Your Ref: OWPC23100
Our Ref: AL/42/19/PL 02-05-2019
Please ask for:
Mr S Davis

Construction of a 10 No. bedroom dementia unit on the grounds of Nyton House Care Home. This application affects the setting of a listed building.

Nyton House Nyton Road Westergate

Thank you for your internet representation made on 19th May 2019 which has been recorded as **'an objection'** with the comments as follows:

Proposed Elevations

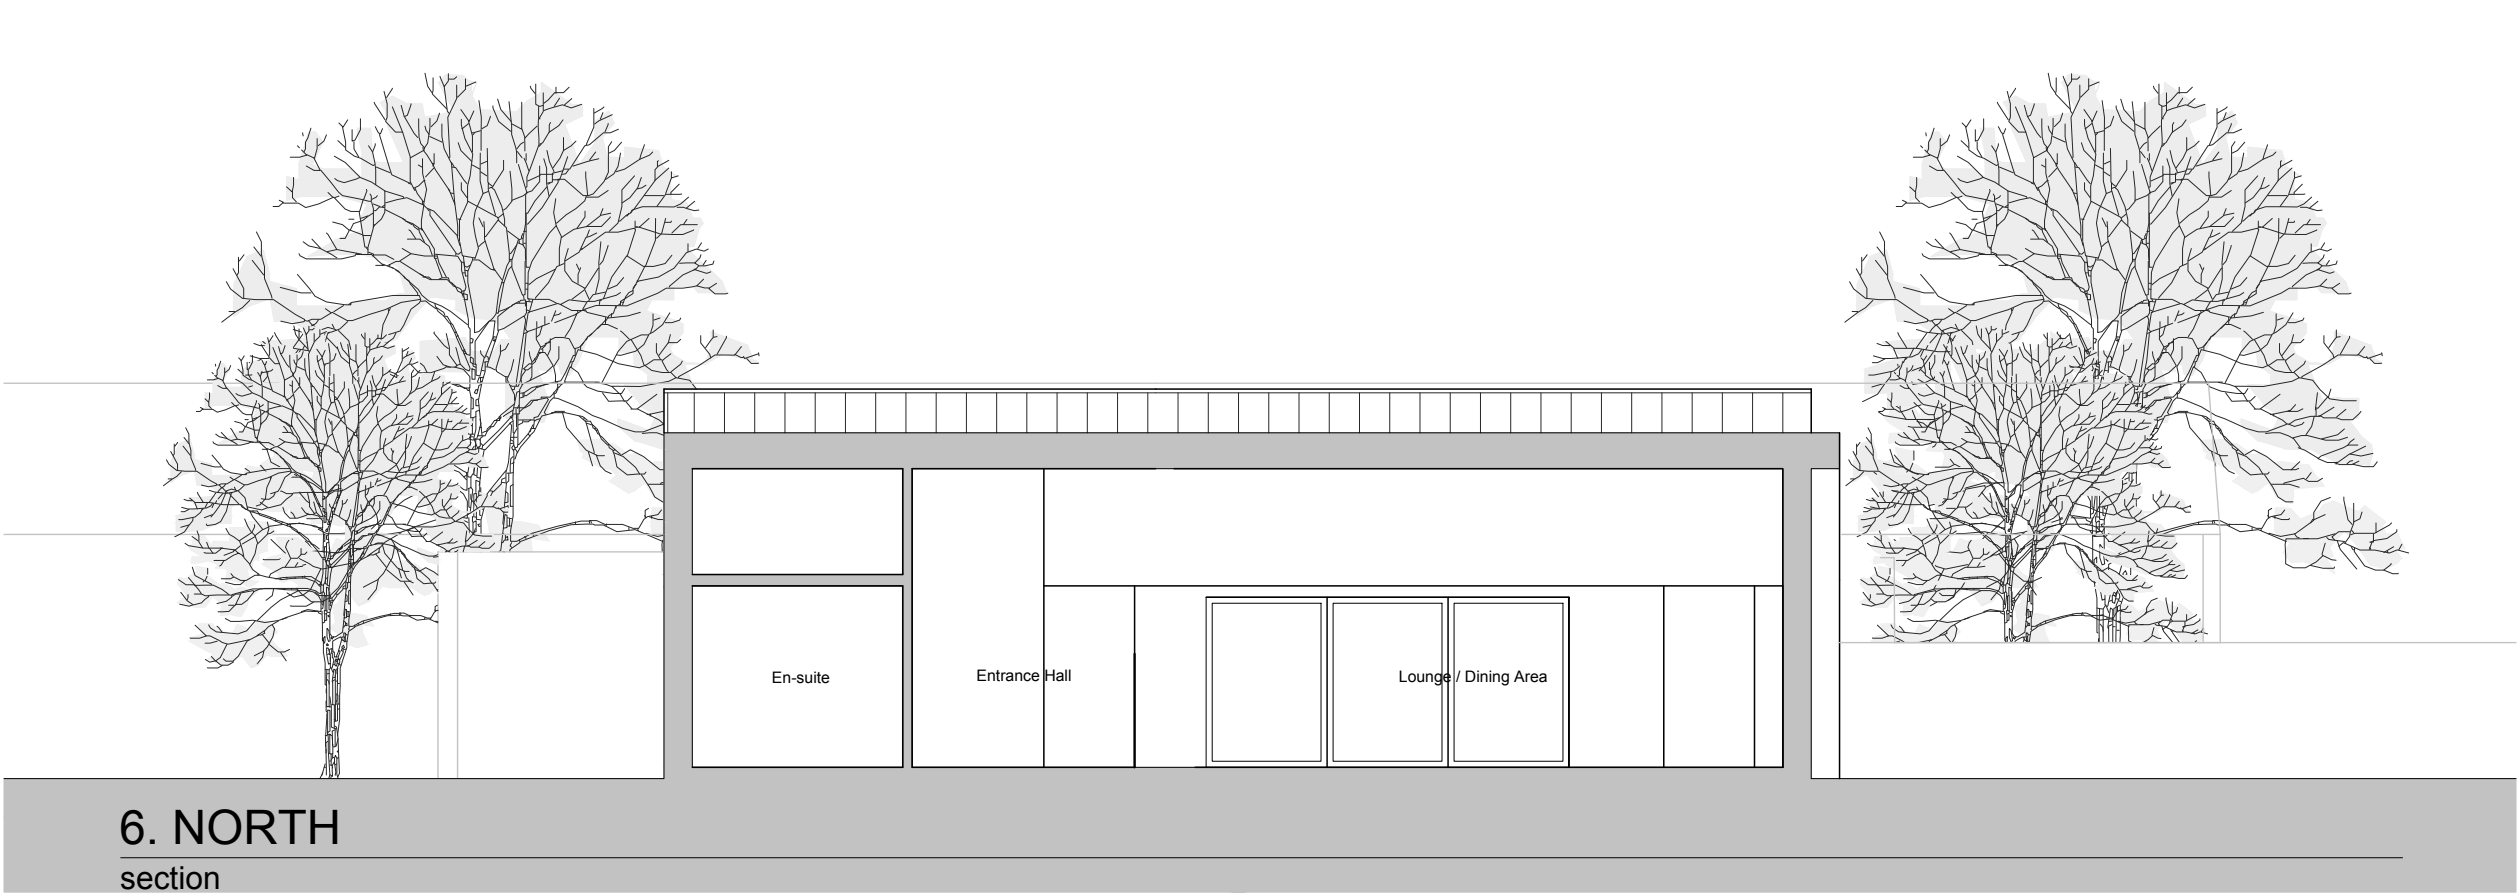
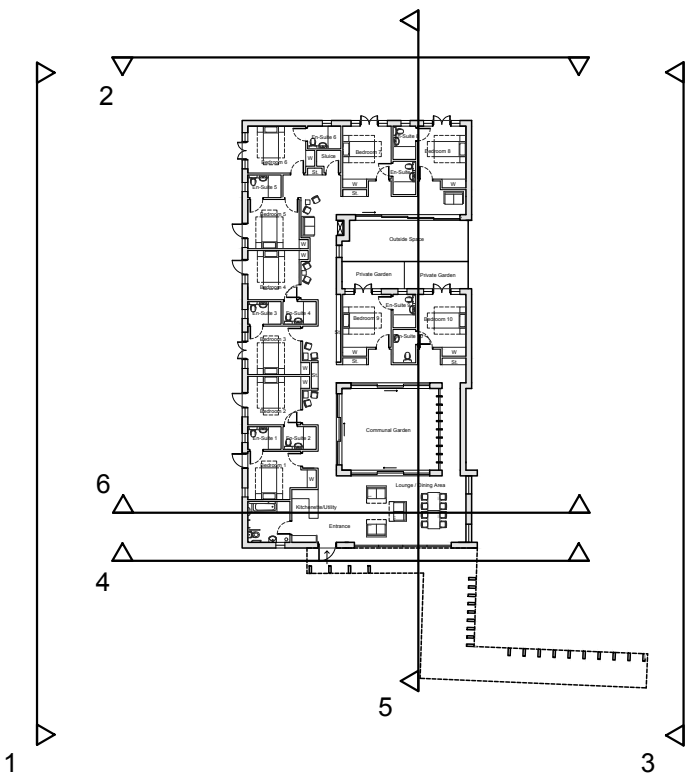
Although the dividing walls between Knighton Grange Cottage and Nyton House are approximately 3 meters high in places, the height and location of the proposals would be clearly seen above the wall. The proposed height of the single-story units of 5.1 meters appears completely excessive; perhaps there is a view to increasing the living space above ground floor level?

Notwithstanding the height issue, the proposed materials for the roof are completely out of context with the key buildings in the close vicinity of Nyton House, three overlooked cottages Wyncote, Nyton Gable, Nyton Farm Cottage and also Knighton Grange Cottage. These properties have roofs comprising hung/peg tiles with the exception of Knighton Grange Cottage being thatched.

The Listed Building Consent Heritage Statement attempts to magnify the impact of the agricultural building to the north of the area in order to justify the proposed design, namely metal zinc cladding which are not part of Nyton estate.

Essentially the proposal places numerous metal structures in the middle of 4 predominantly brick/flint/thatched properties.
